11 November 2025

Our Ref: R/2025/6/A
File No: 2025/668629
Your Ref: SSD-80211463

**Advice on EIS – Mixed use development with in-fill affordable housing –
164-194 William Street, Woolloomooloo – SSD-80211463**

Landscape Plans Scale: 1:200 @ A1
Public Domain Concept Plan

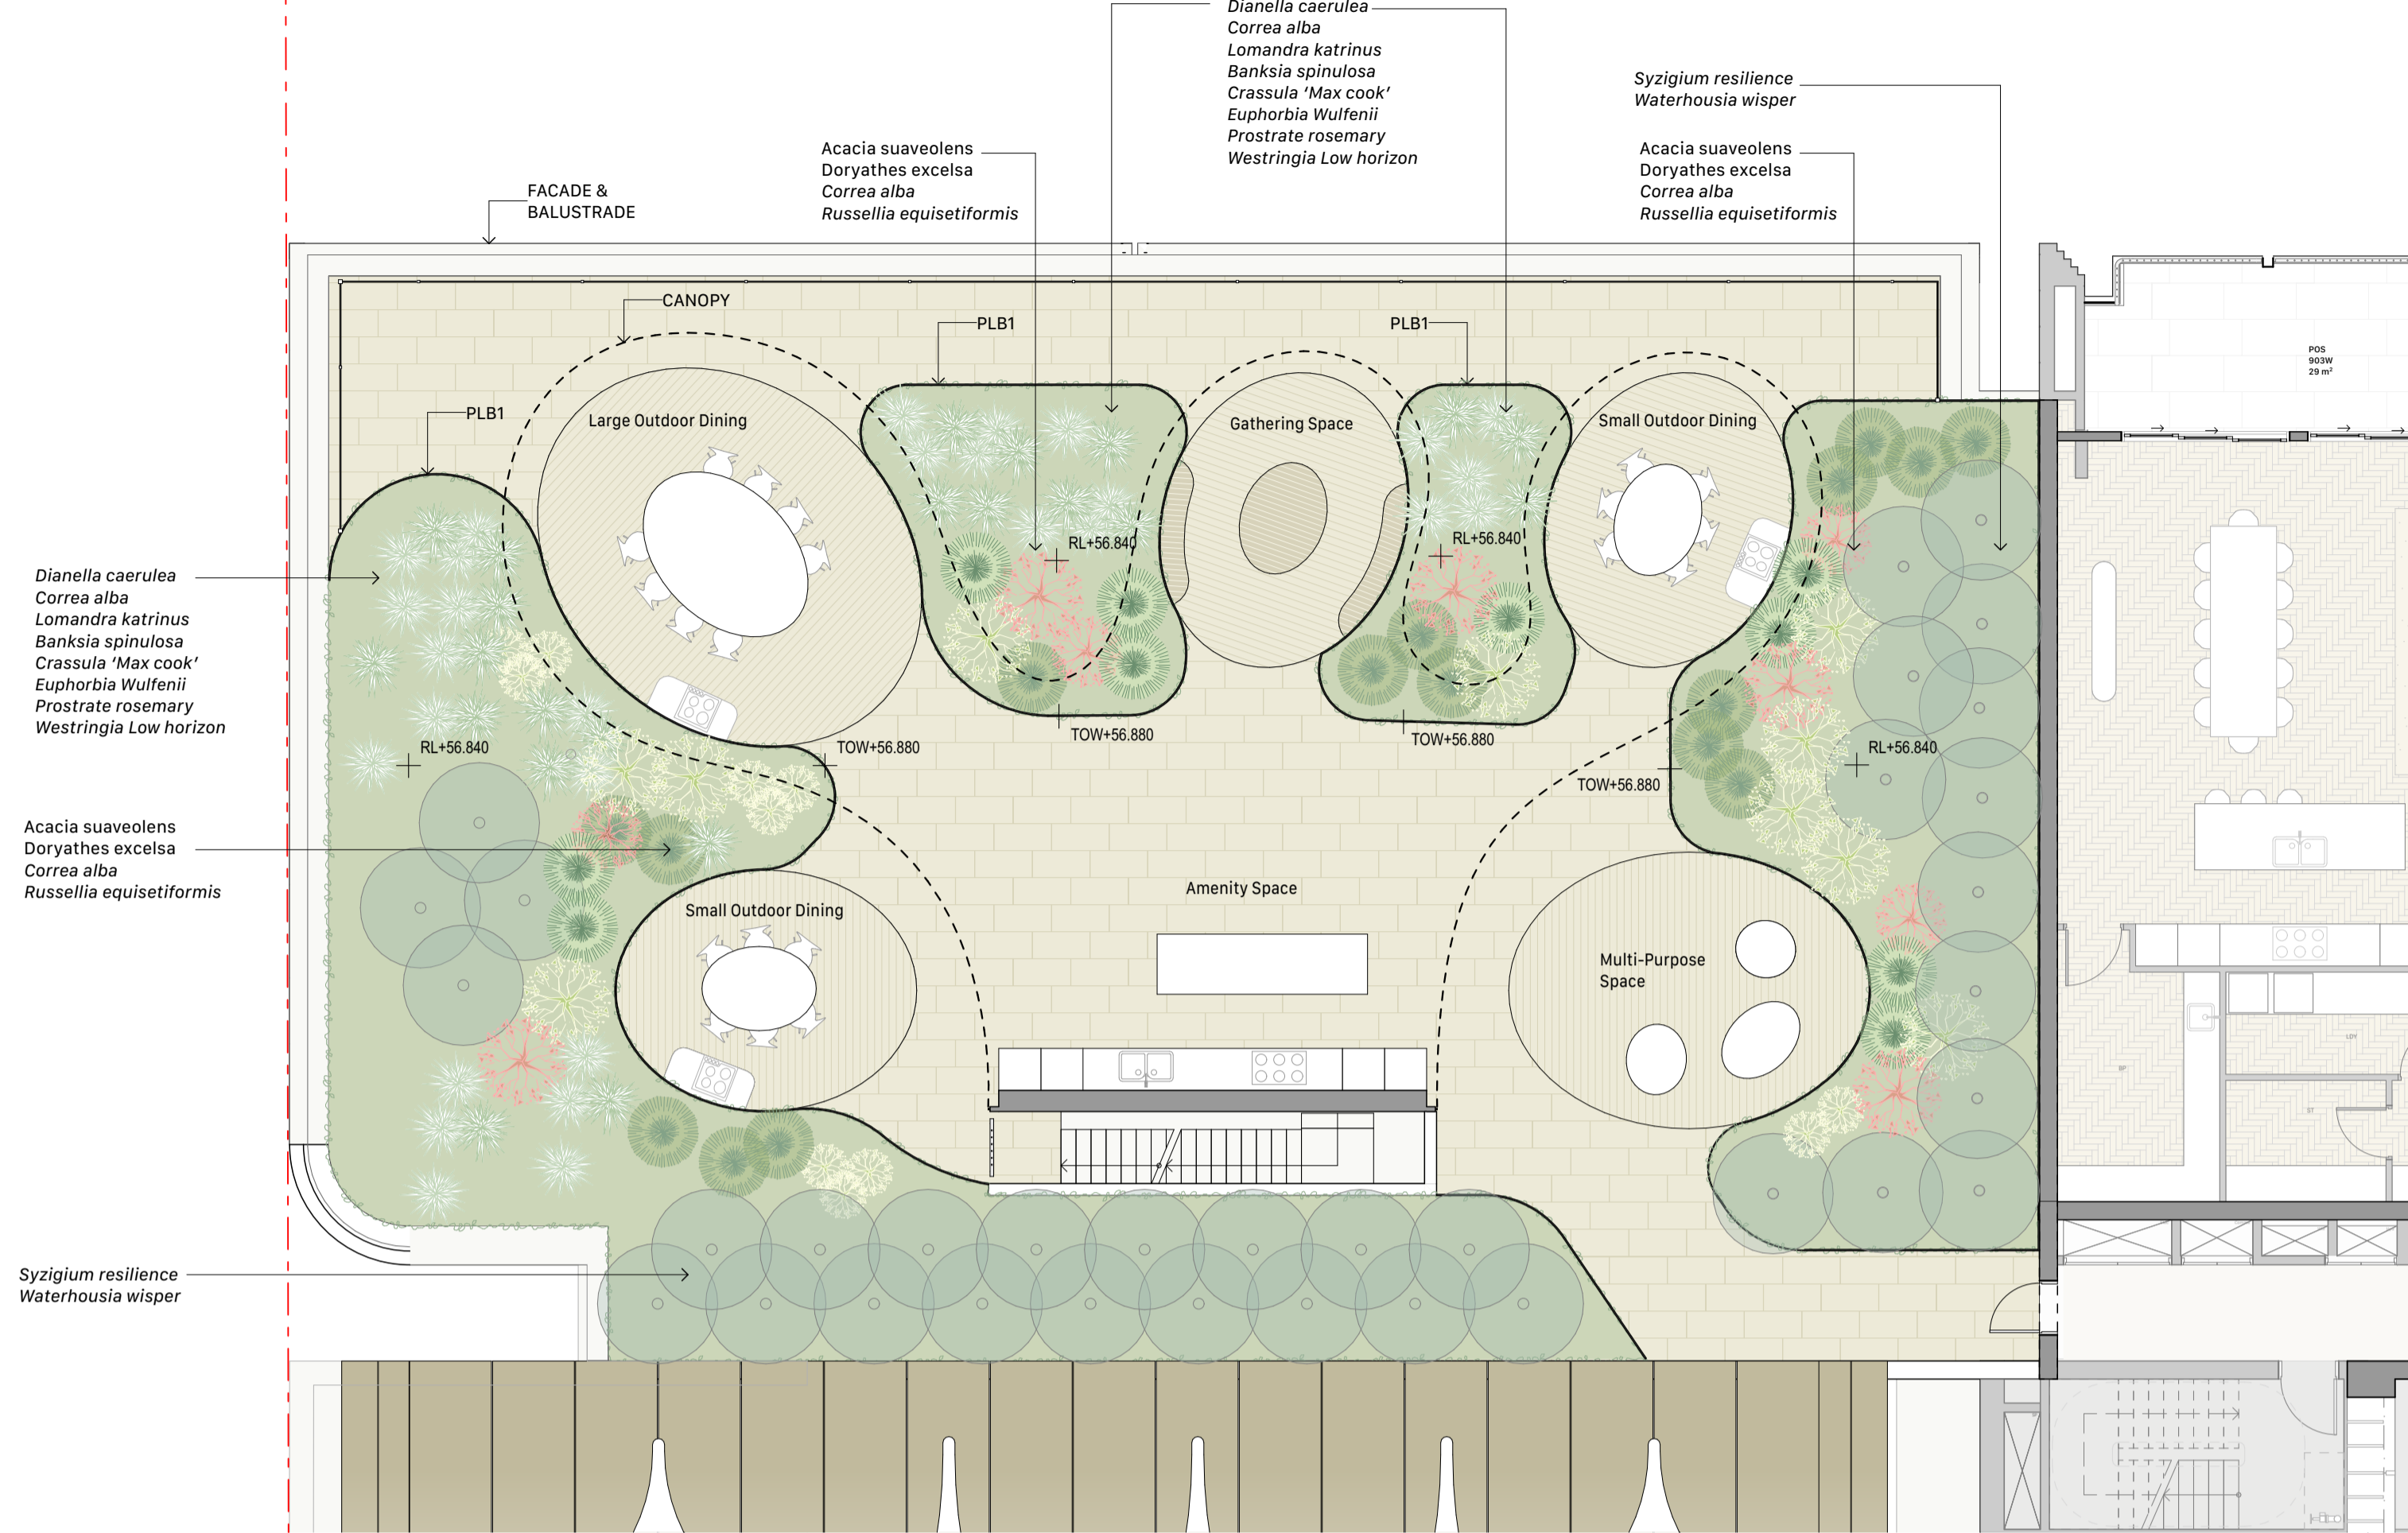
While the indicative design for the VPA laneway is supported in-principle, detailed levels, cross sections and long sections are to be provided to clarify proposal and the landscape details must be further development in accordance with the City's Parks Code. A lighting proposal for the laneway is also required and the applicant should obtain detailed lighting requirements from the City's Public Domain team.

The City has requested, prior to the subject SSD being lodged, that the entirety of Judge Lane be converted into a shared zone, this includes both the north-south and east-west street sections. Landscape works are to be extended to include the transformation of Judge Lane into a shared zone, with detailed design of interfaces between Walumay Neighbourhood Park and Judge Lane, particularly regarding level changes and accessibility.

A diagram must be submitted indicating the expected extent of works to be undertaken within the public domain. This is to correlate with the area of expected levels and gradient and interfaces to the surrounding public domain.

1 PLAN William West Level 09 Communal Terrace
1:100

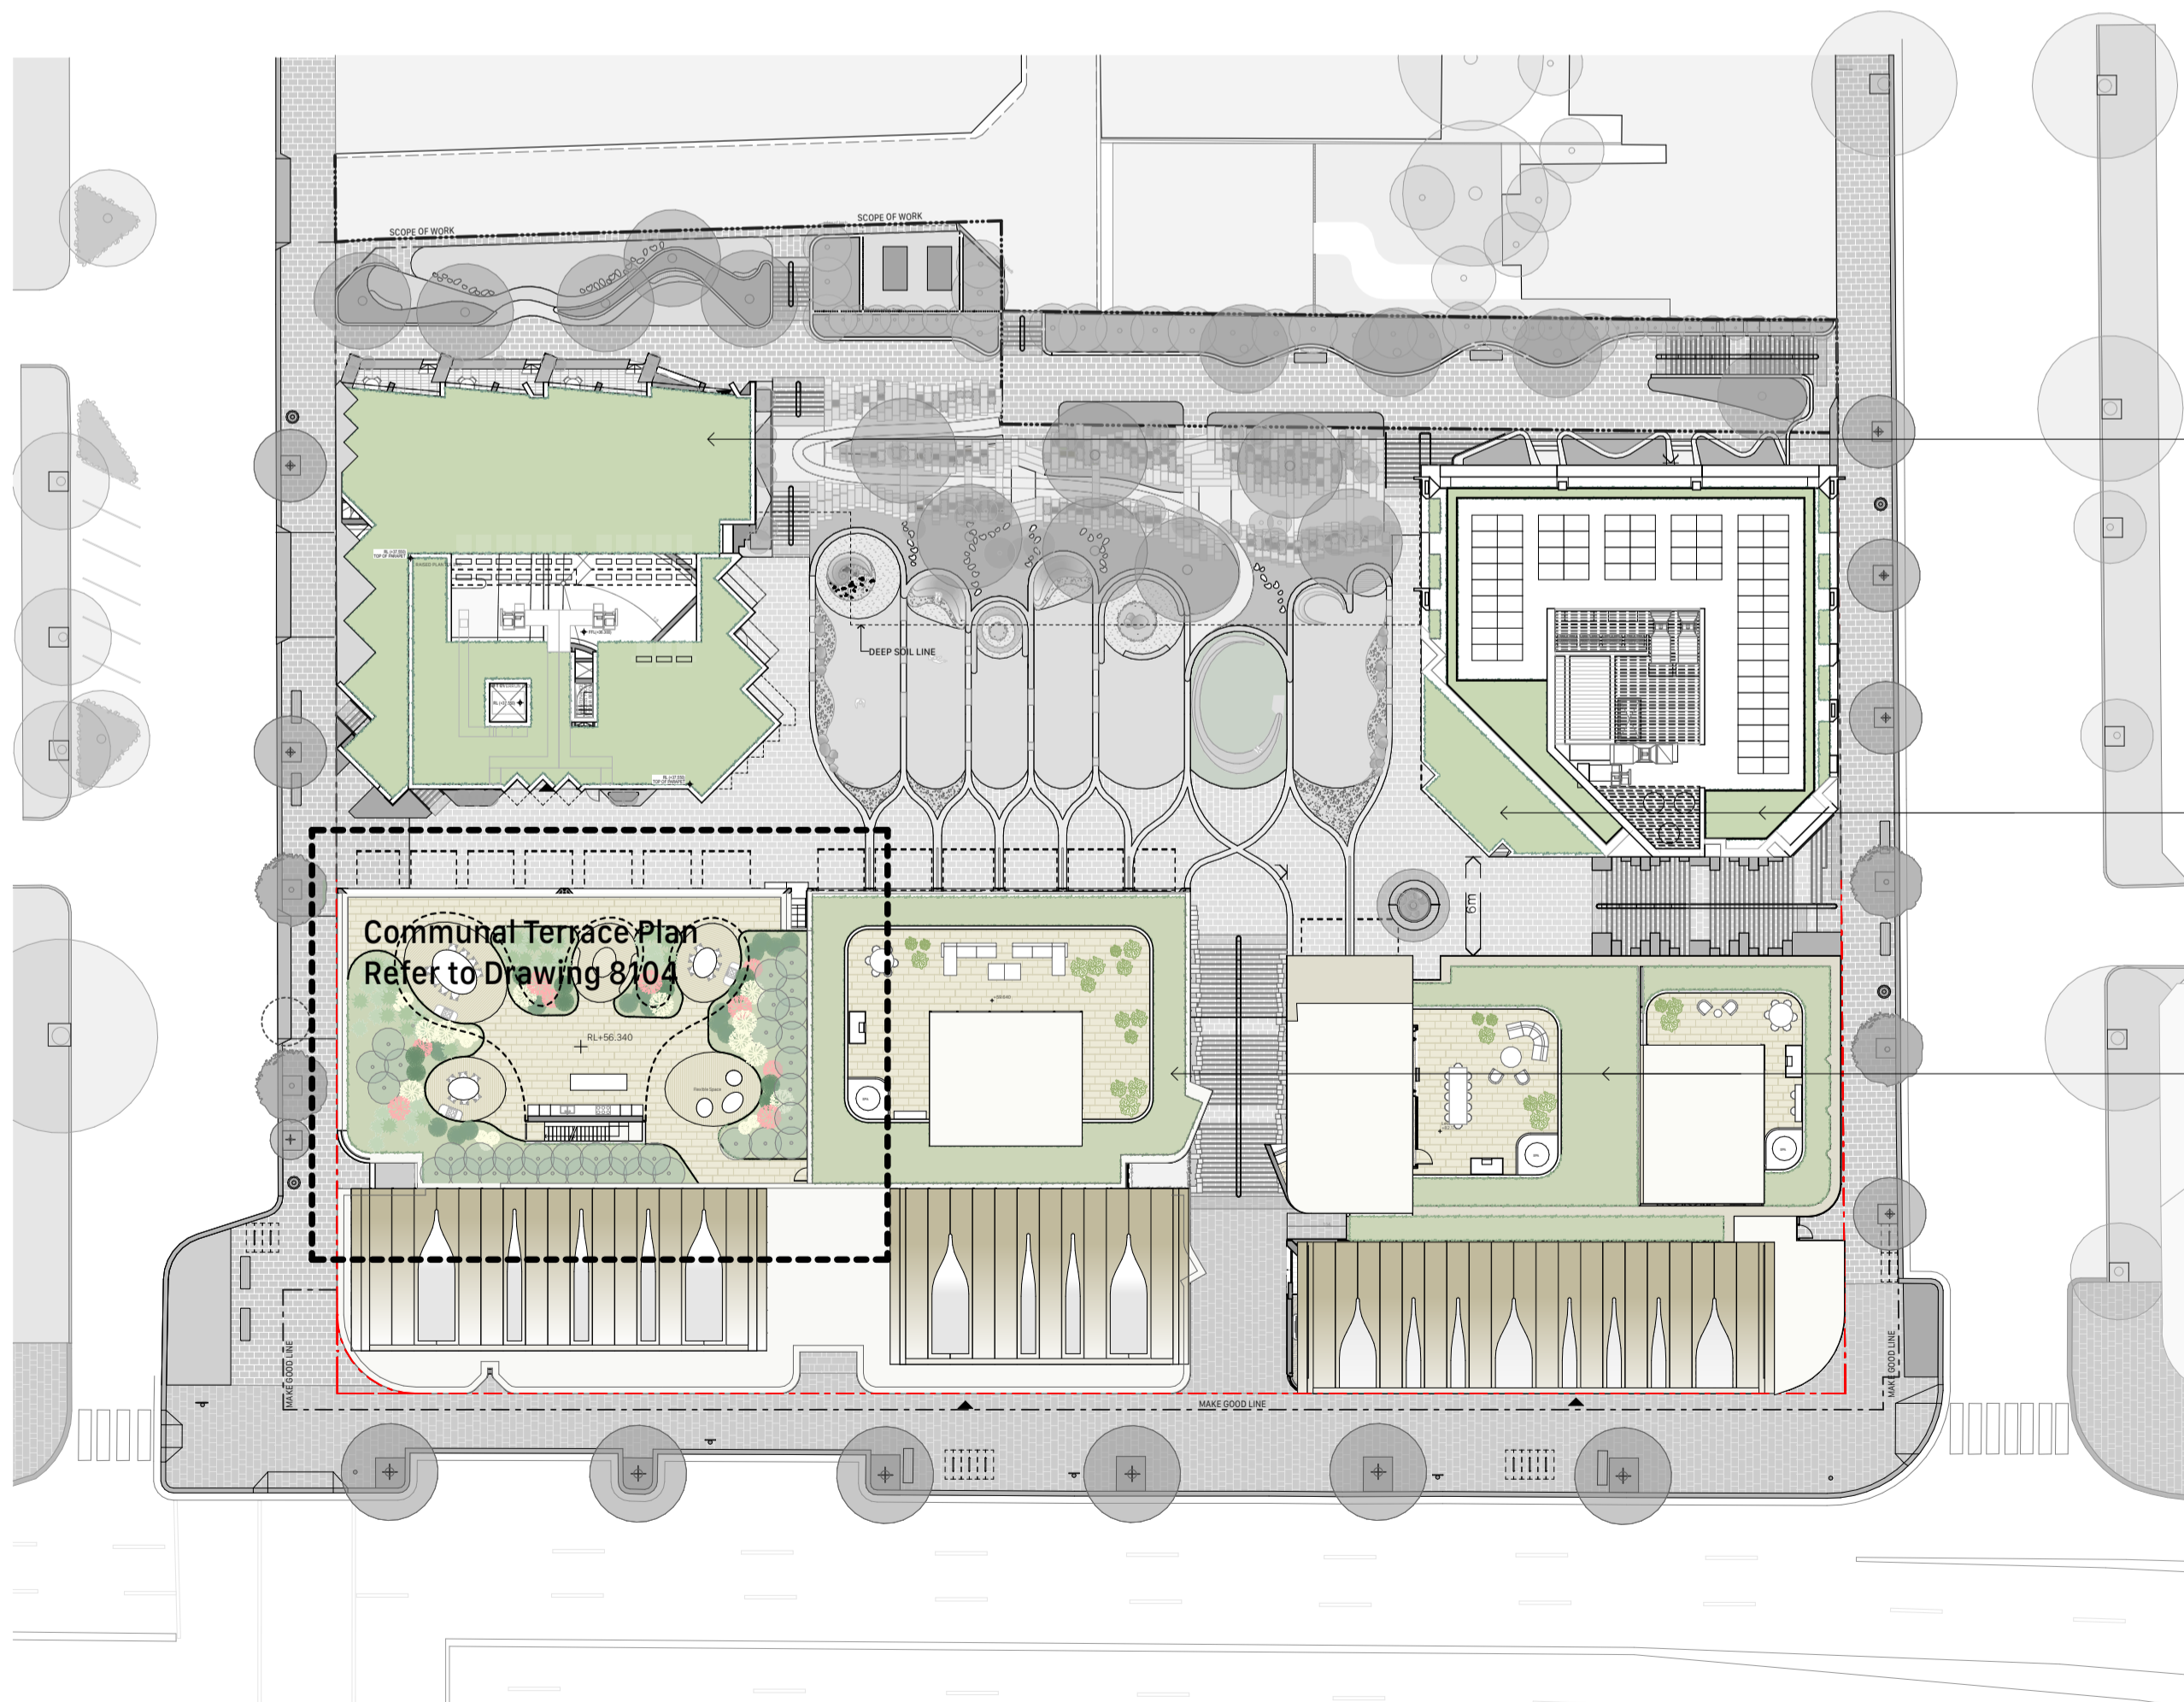
The design of the level 8 roof terrace requires further development. The northern edge is currently unprogrammed, while the 5 defined areas appear to cater to very similar purposes. The extent of the curvilinear canopy is also unclear, given the inconsistencies between the architectural and landscape drawings.

- The extent of green roofs should be maximised, including perimeter planting around penthouse terraces. The landscape report only lists 4 species for green roofs. Further opportunities to maximise biodiversity on green roofs should be explored;

- Canopy trees should be accommodated on the roof terraces, with soil volume consistent with the Sydney Landscape Code.

5 SECTION VPA/Escarpment Interface
1:100

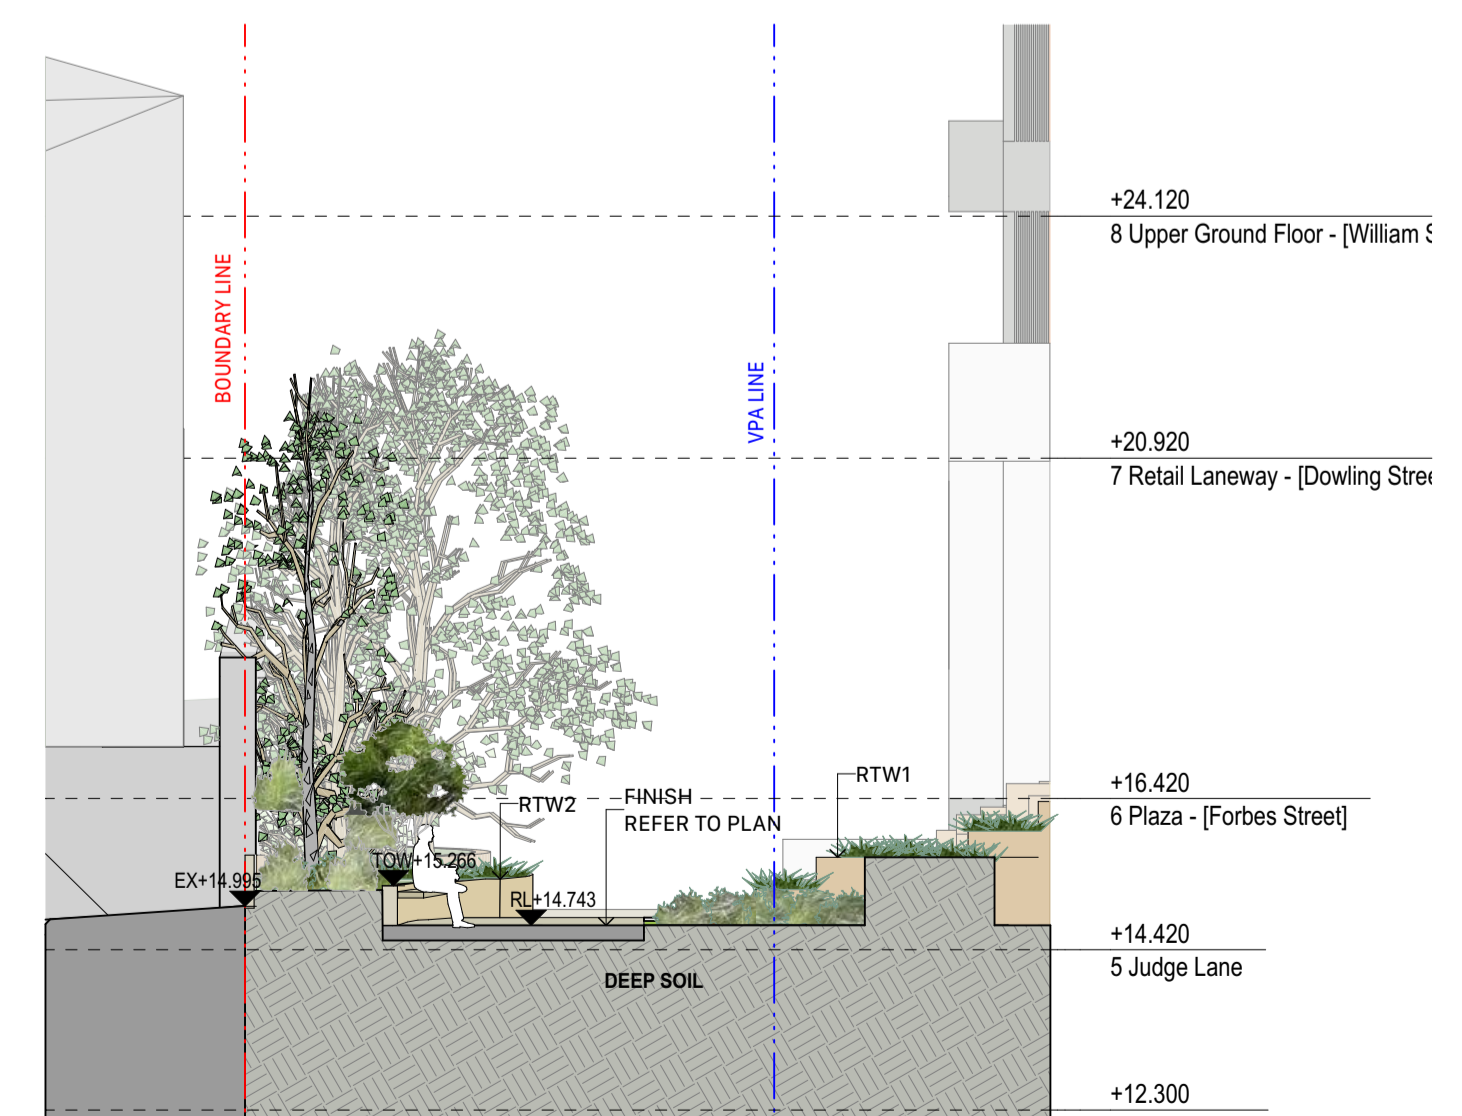
It is noted that the design of the public park is strongly founded upon the Design with Country framework. The sandstone 'escarpment,' the 7 'Peace Keeper' trees and the form of the seating areas are important elements to be retained. However, the extent of the 'escarpment' must not encroach into the land to be dedicated to the City.

There is also concern that the tree planting within the 'escarpment' may have access to very limited soil volume. The design of tree pits in the 'escarpment' and other raised planters should be provided to demonstrate that the soil volume is consistent with the City's Landscape Code, and that root access to the surrounding soils have been maximised.

The proposed landscape design must provide a clear delineation between private property and the boundary of the land to be dedicated. This includes paving, ramps, garden beds, stairs etc. Any planter connected with the 'escarpment' must include a clear edge indicating the extent of land to be dedicated.
